KITTITAS COUNTY

DEPARTMENT OF PUBLIC WORKS

MEMORANDUM

TO: Community Development Services
FROM: Taylor Gustafson, Environmental/Transportation Planner
DATE: March 26, 2019
SUBJECT: LPF-19-00003 Palomino Fields Division 2

Surveyed by LMH Scale 1" = 300'
Drawn by Tml/FCS Sheet 1 of 5
Checked by FCS Project No. 18146

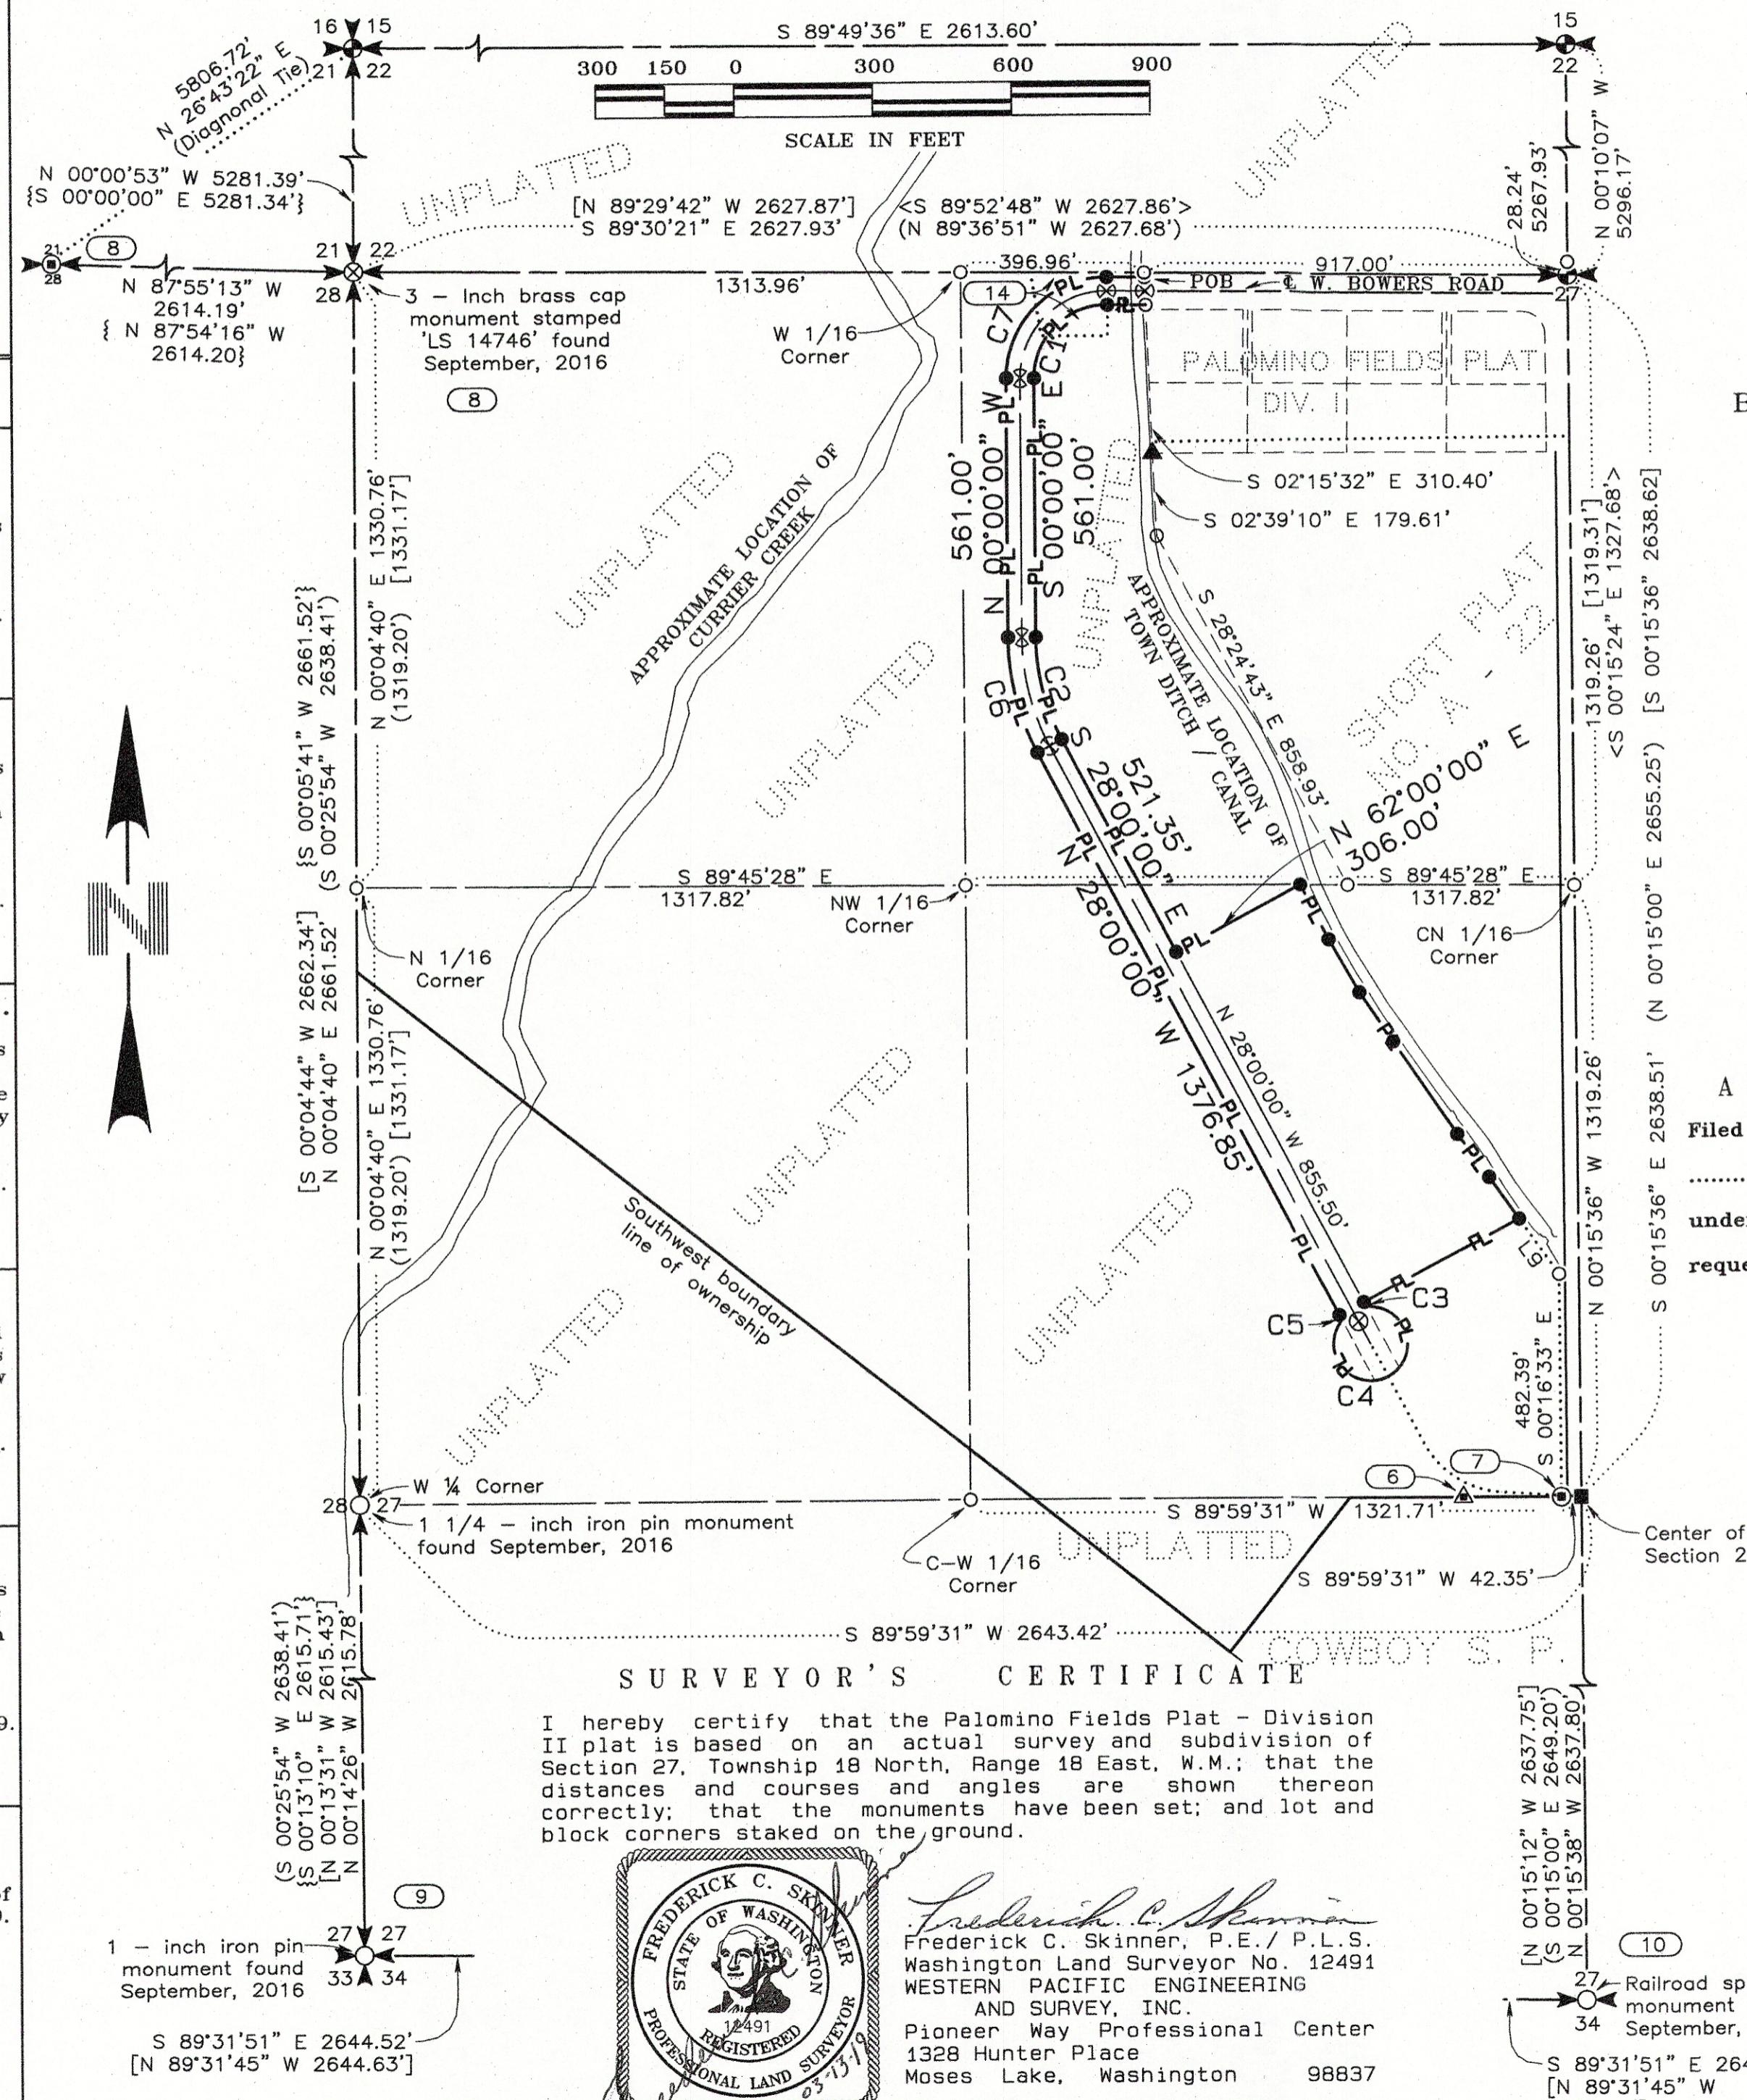
5. The exclusive use statement refers to the named parties in the Surveyors statement.
6. There are no named parties in the surveyor's statement (multiple sheets).
7. The proposed division actually involves a number of parcels, owned by two separate entities. The limits of all the involved parcels need to be surveyed with locations shown on the face of the plat. The concept of a "Parent Parcel" is the original lands involved, prior to proposed subdivision. The practice of outlining the project limits, and labelling them to be the parent parcel, is contrary to standard survey practice. Also note that the remaining area of the involved lots will need to be labeled with a lot, parcel or tract name as well as an area.

Surveyed by LMH Scale 1" = 100'
Drawn by Tml/FCS Sheet 2 of 5
Checked by FCS Project No. 18146

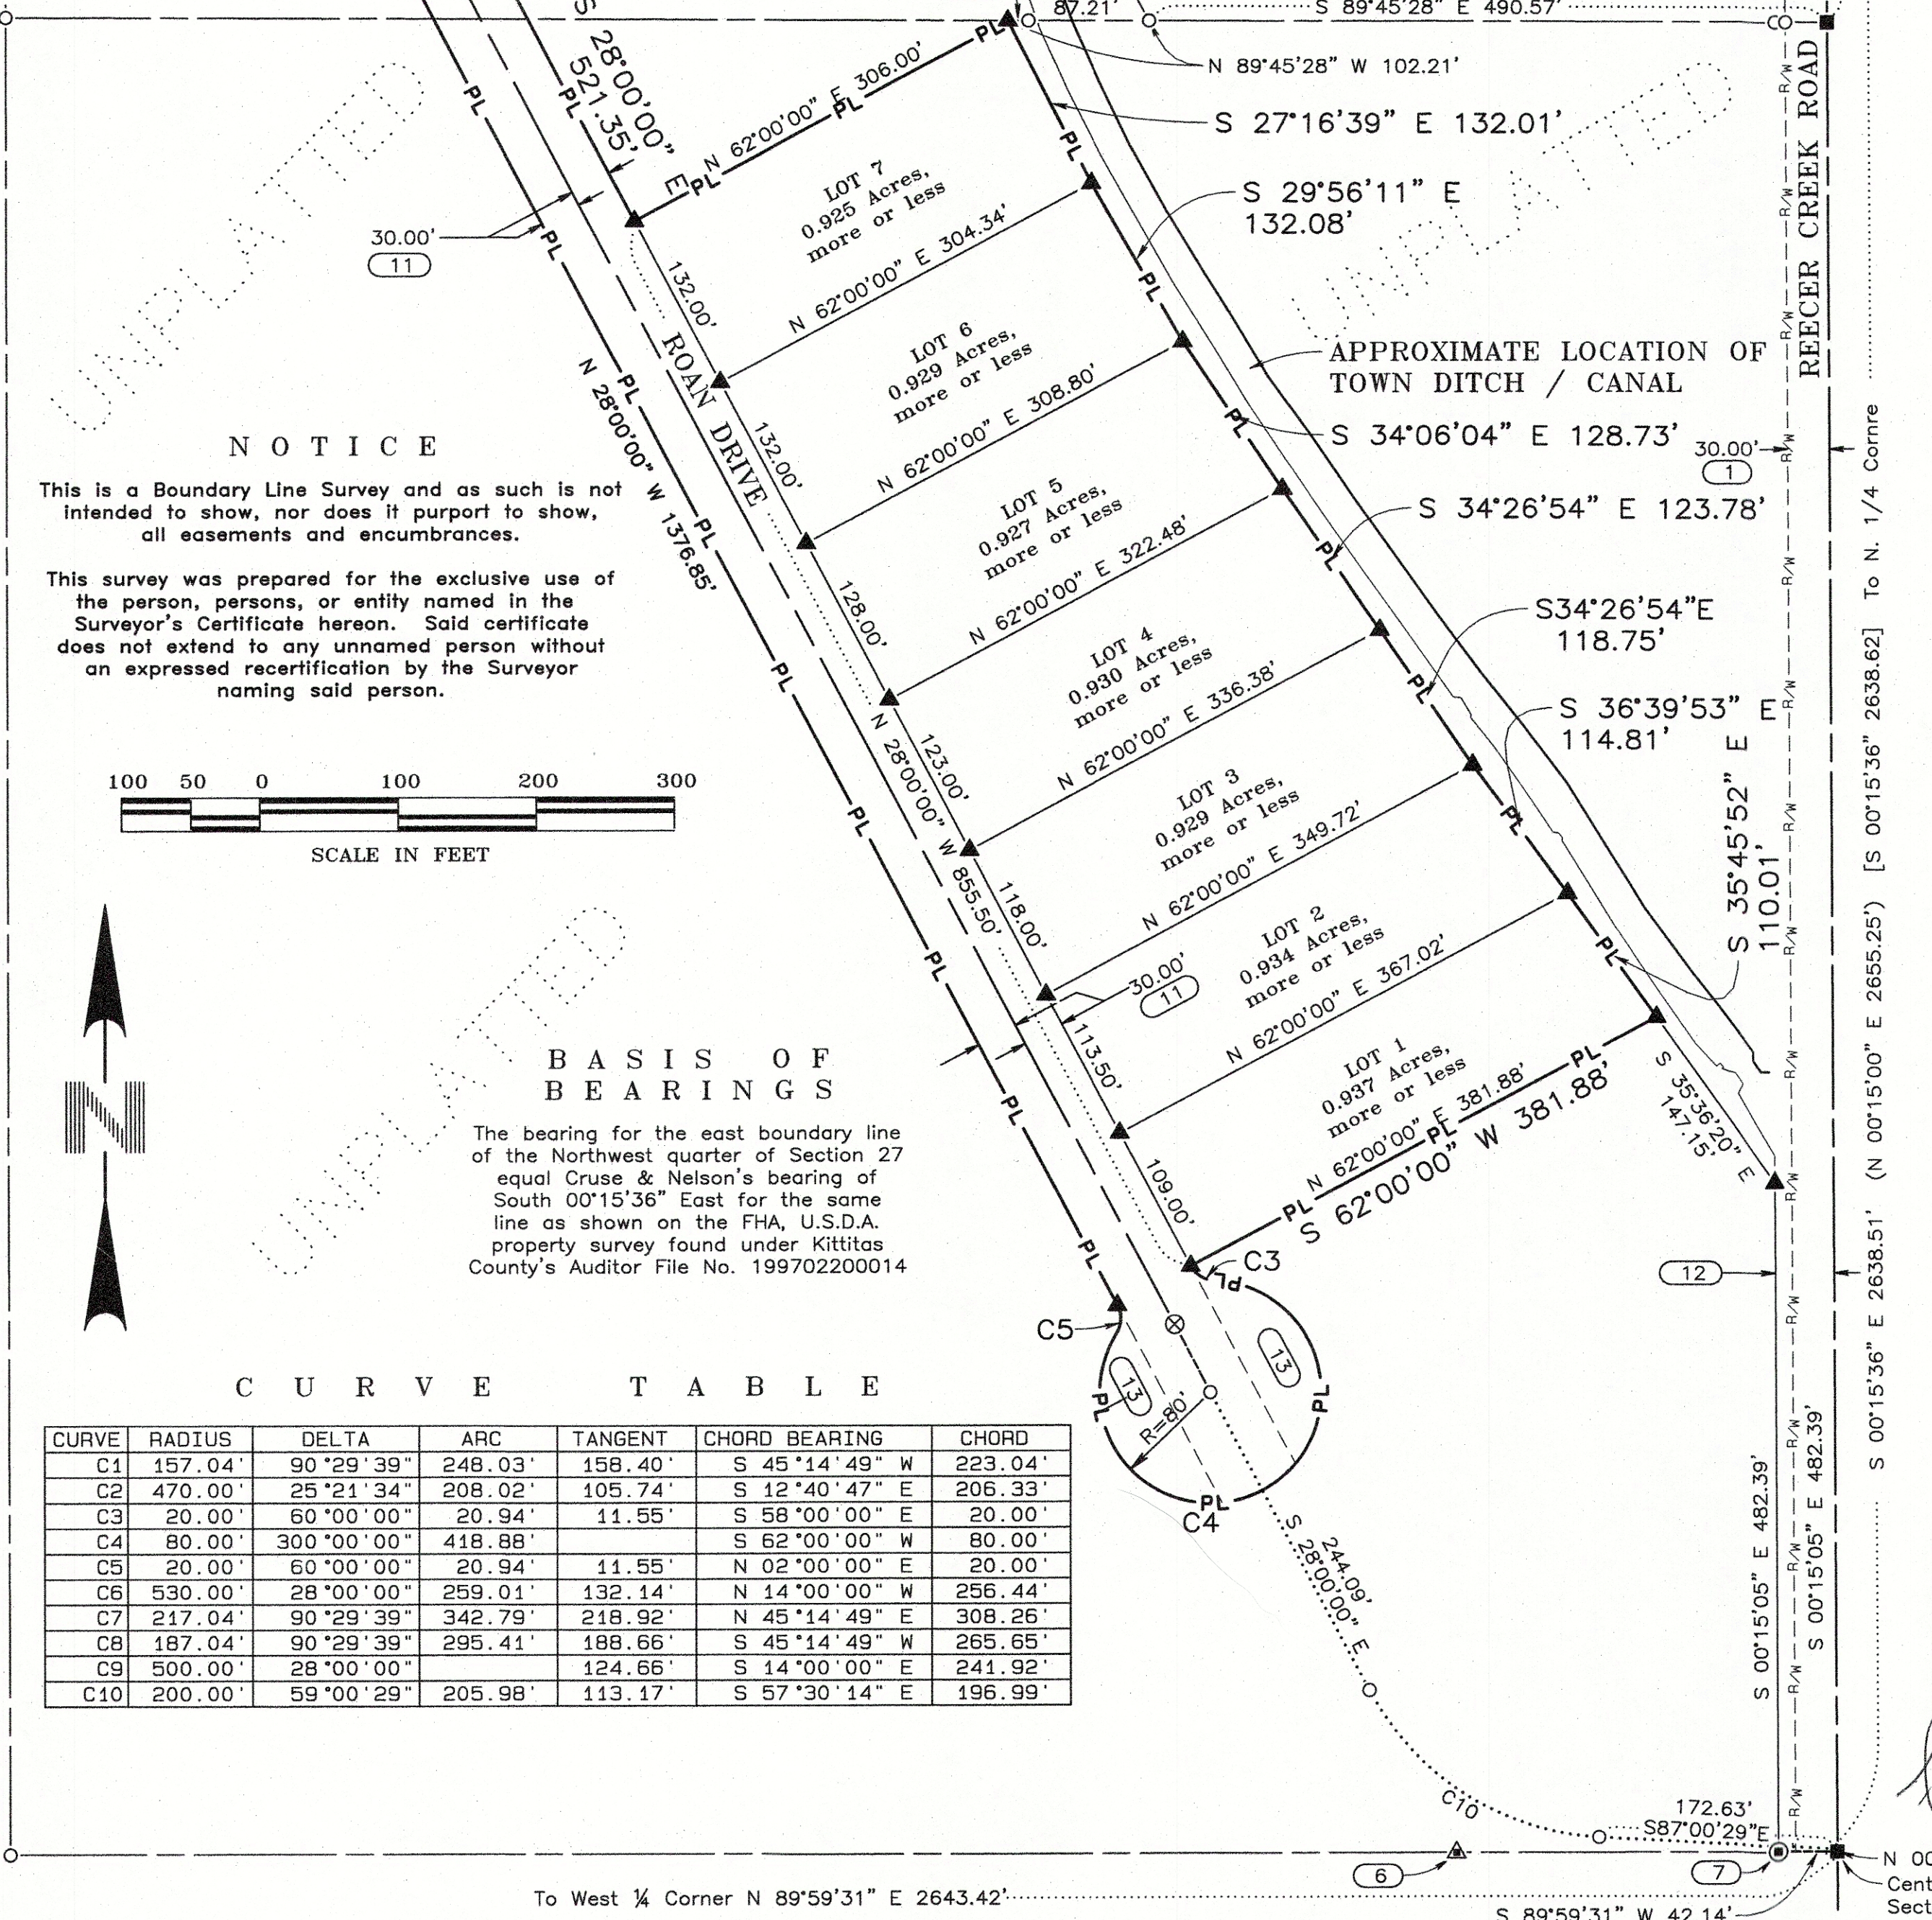
8. As the Easternmost boundary lines of lots 1-7 fall against the town ditch canal, it is assumed that the canal boundary is coincident with the lot boundaries. It is also assumed that the

areas shown as being “more or less” may reflect the ambulatory nature of bodies of water OR the necessity of lot owners to be able to make claim to additional lands in the event additional data is discovered locating the deed description of the canal. A note explaining such would greatly assist future parties.

9. In the legend, the text adjacent to the fourth symbol has a questionable date. If dates unknown, not labelling any date at all would be sufficient.
10. Curve 2 contained within the curve table appears to be incorrect, as it does not match the closure report.
